Application for a non-material amendment following a grant of planning permission.

Construction of a single storey rear and side extension, first floor extension to outrigger and replacement windows to existing dormer extensions.
At 17 Hansler Road London Southwark SE22 9DJ

This application seeks approval to replace one previously consented sash window with a casement window, replace an existing uPVC sash window with a new casement window, add one new window to the side elevation of the outrigger, previously consented former window infill changed from inset brick to flush brick detail at 17 Hansler Road. These works shall be in addition to those approved in the prior consents.

Planning	Proposed . NMA Application Elevation and Cross Section
project	17 Hansler Road East Dulwich . London . SE22 9DJ
client	Mr and Mrs Macartney
job no . 048 . (3) stage	.3 type / place .201 series / number
	-- revision

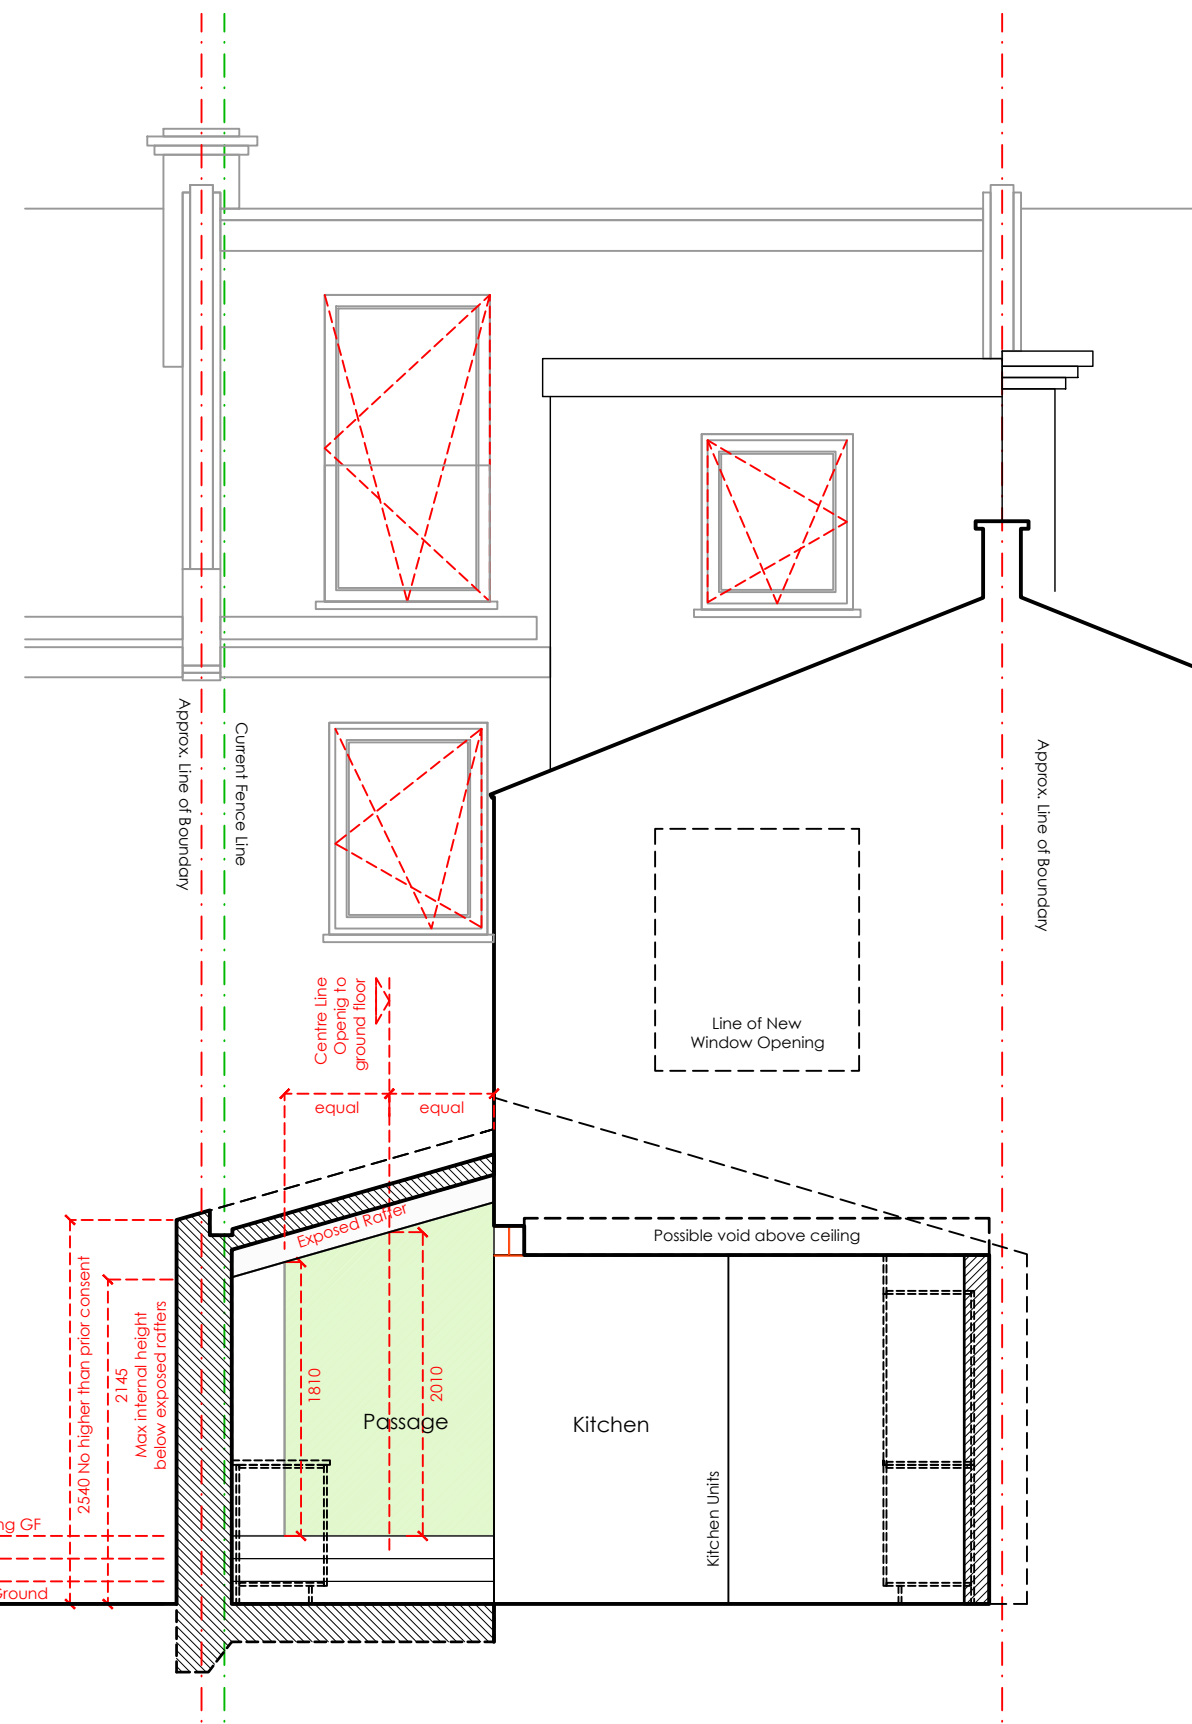
Window 1 . First Floor Rear Window to Outrigger. The window is changed from previously proposed sash window to be aluminium framed and powder coated and tilt and turn in function.

Window 2 . Main Building Rear Elevation, First Floor Bedroom Window. With the remainder of the windows becoming aluminium framed and powder coated the existing uPVC sash is to be replaced to match the new windows. The window opening is not to be enlarged.

Window 3 . Outrigger Flank Elevation. New window to be formed within the new bathroom. As this window is on the inside flank elevation the glazing is to be fixed and frosted. The window is to be aluminium framed and powder coated.

Former Window . Previously consented former window infill changed from inset brick to flush brick detail to ensure brickwork stitching (new to old) can be carried out.
